Re: Casa Del Rey Parking Lot Grading and Drainage Engineer's Stamp Dated 3-12-02, (H11/D64)

RE: Casa del Rey Parking Lot (H11/D64)

Re: Casa del Rey Parking Lot Grading and Drainage Plan Engineer's Stamp Dated 3-12-02, (H11/D64)

ROUGH GRADING APPROVAL		DATE
ENGINEER'S SEAL	CASA DEL REY PARKING LOT	DRAWN BY BMP
	FINAL GRADING AND DRAINAGE	DATE 03/12/02
	TERRA WEST, LLC	22029GR.DWG
	8509 JEFFERSON NE ALBUQUERQUE, NEW MEXICO 87113 (505)858-3100	SHEET # 1
RONALD R. BOHANNAN P.E. #7868		JOB # 220029

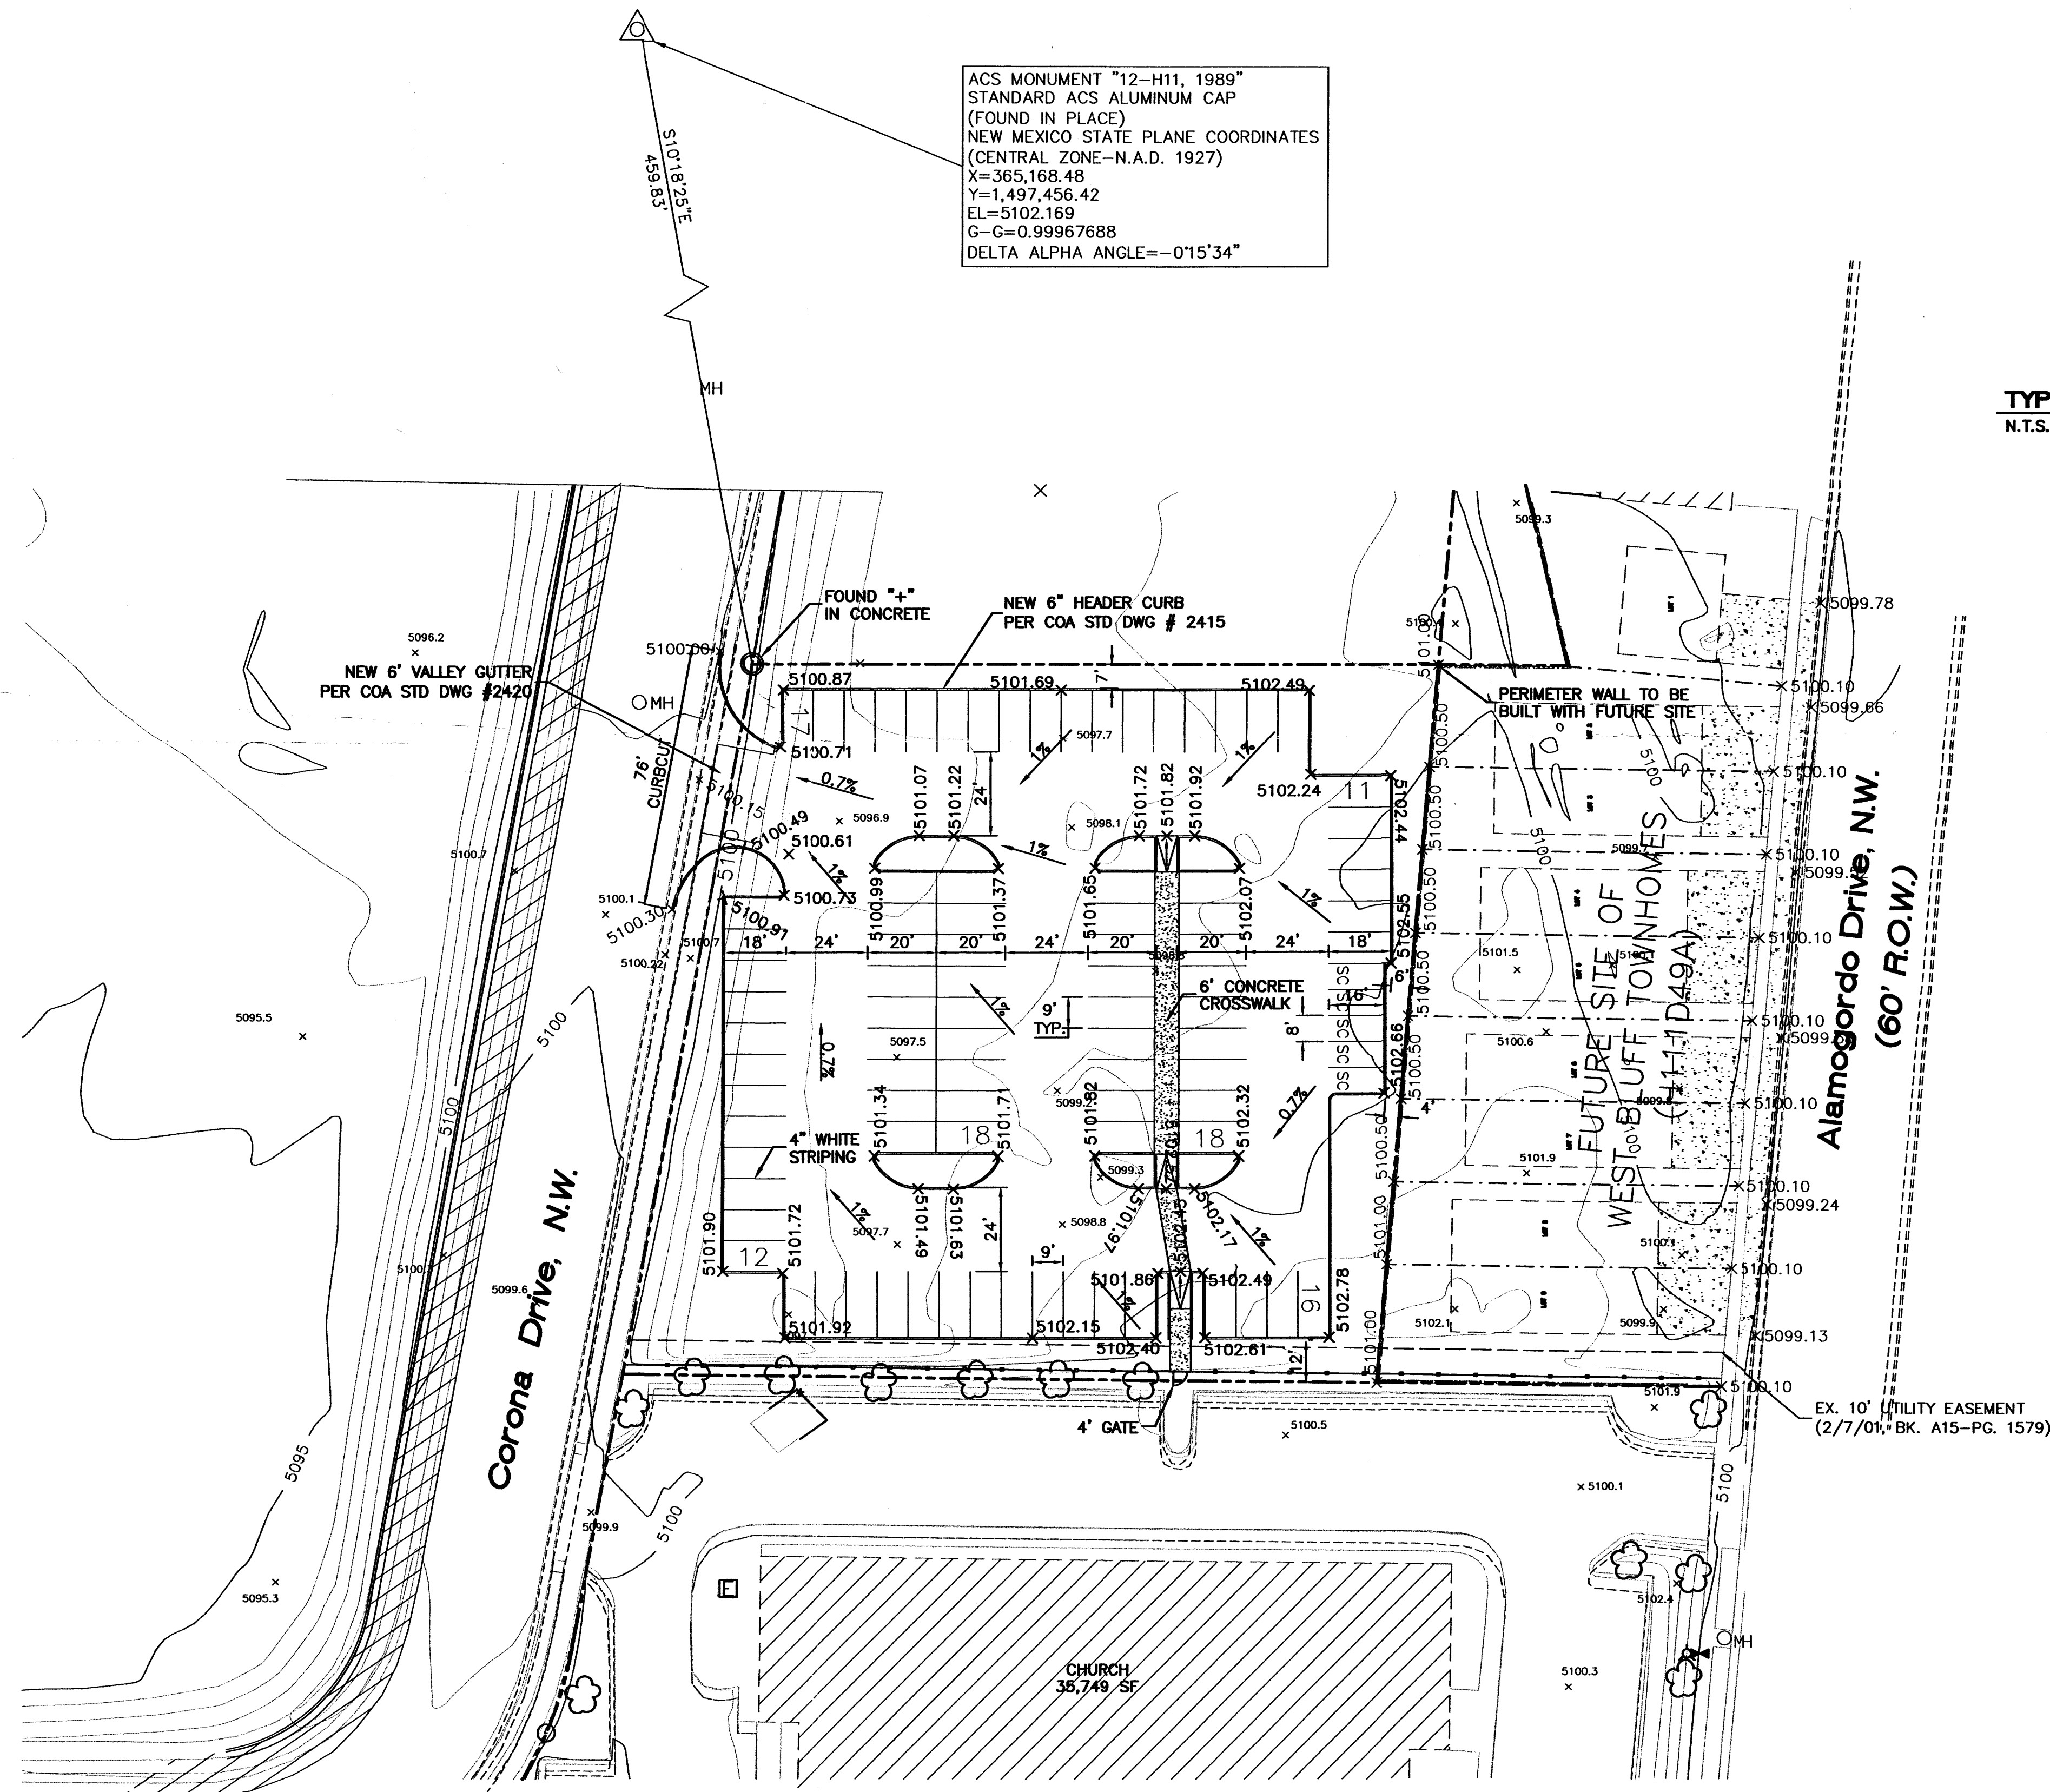
1. Please address if there are any off-site flows east of the proposed parking lot. It also appears that the portion to the east will be subdivided and drain to Alamogordo Street? If this is the case, spot elevations will be required between the lot line of the proposed parking area and the property to the east. Also, include spot elevations along Alamogordo Street as well.

A Grading and Drainage Plan was prepared for the West Bluff Townhomes (H11/D49A) located east of this site. We have added the grades and layout for the Townhomes to show the continuity between the two projects.

ROUGH GRADING APPROVAL		DATE
ENGINEER'S SEAL	CASA DEL REY PARKING LOT	DRAWN BY BMP
	FINAL GRADING AND DRAINAGE	DATE 03/12/02
	TERRA WEST, LLC	22029GR.DWG
	8509 JEFFERSON NE ALBUQUERQUE, NEW MEXICO 87113 (505)858-3100	SHEET # 1
RONALD R. BOHANNAN P.E. #7868		JOB # 220029

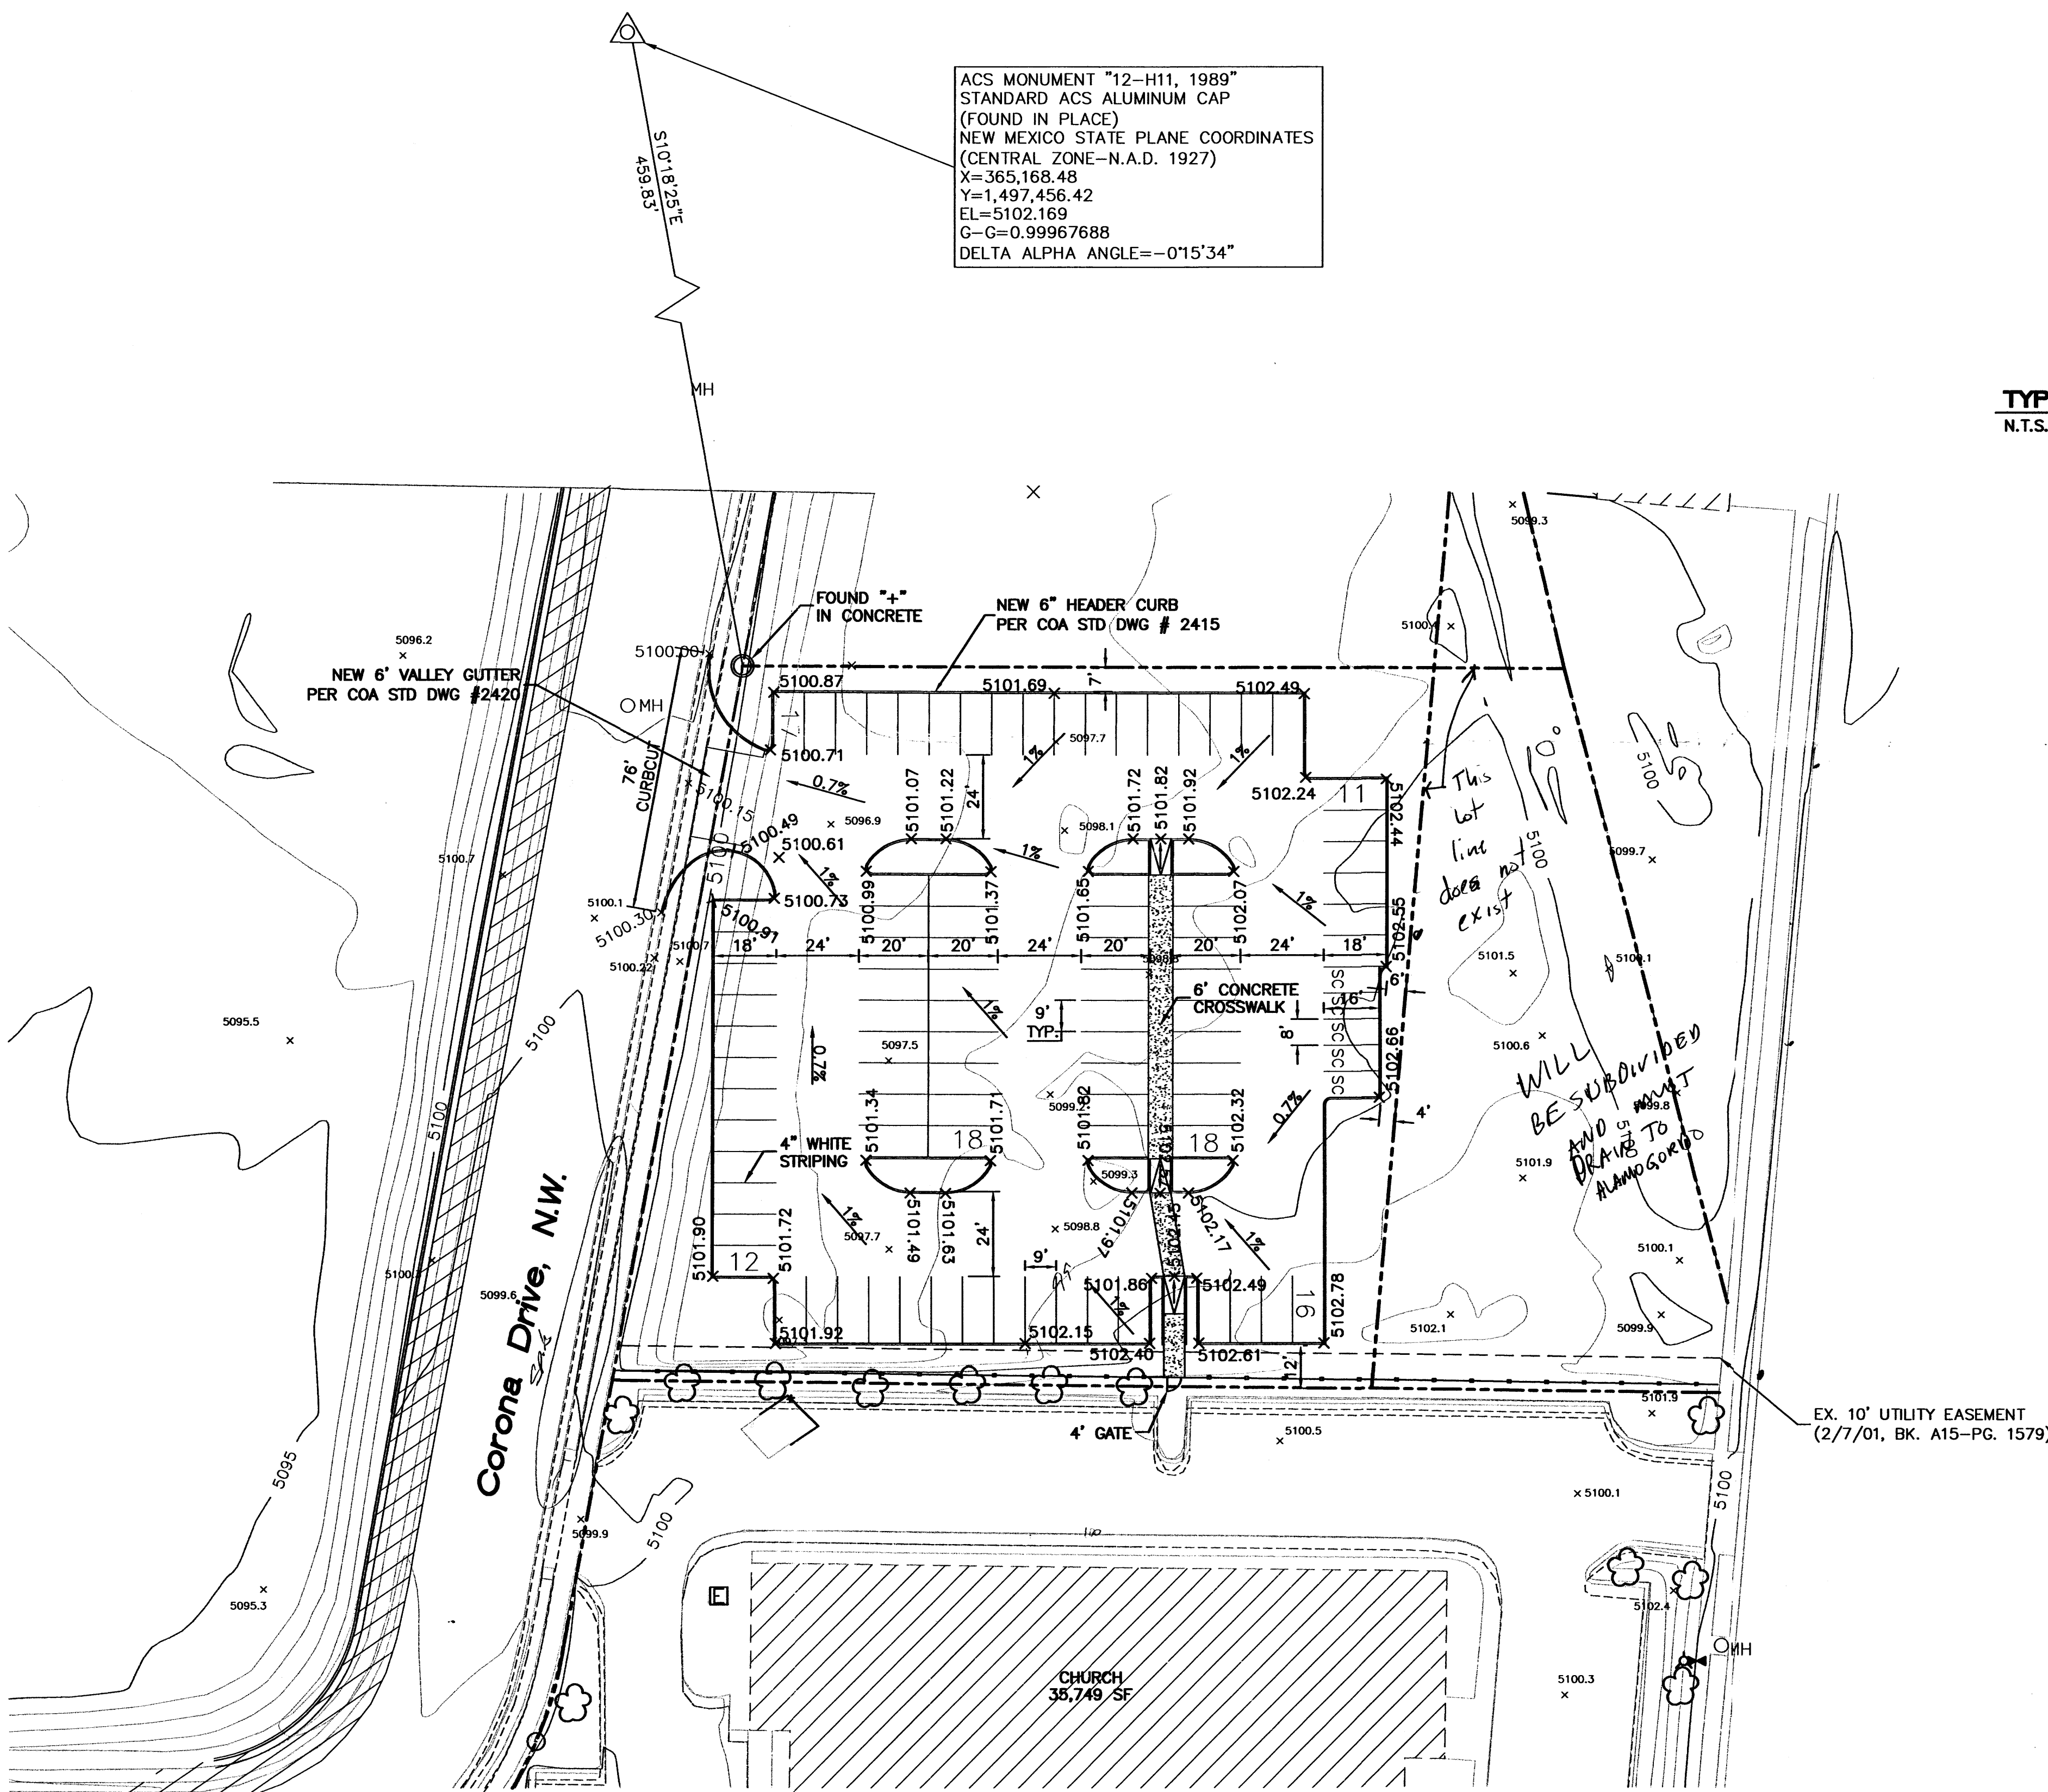
Please address if there are any off-site flows east of the proposed parking lot. It also appears that the portion to the east will be subdivided and drain to Alamogordo Street? If this is the case, spot elevations will be required between the lot line of the proposed parking area and the property to the east. Also, include spot elevations along Alamogordo Street as well.
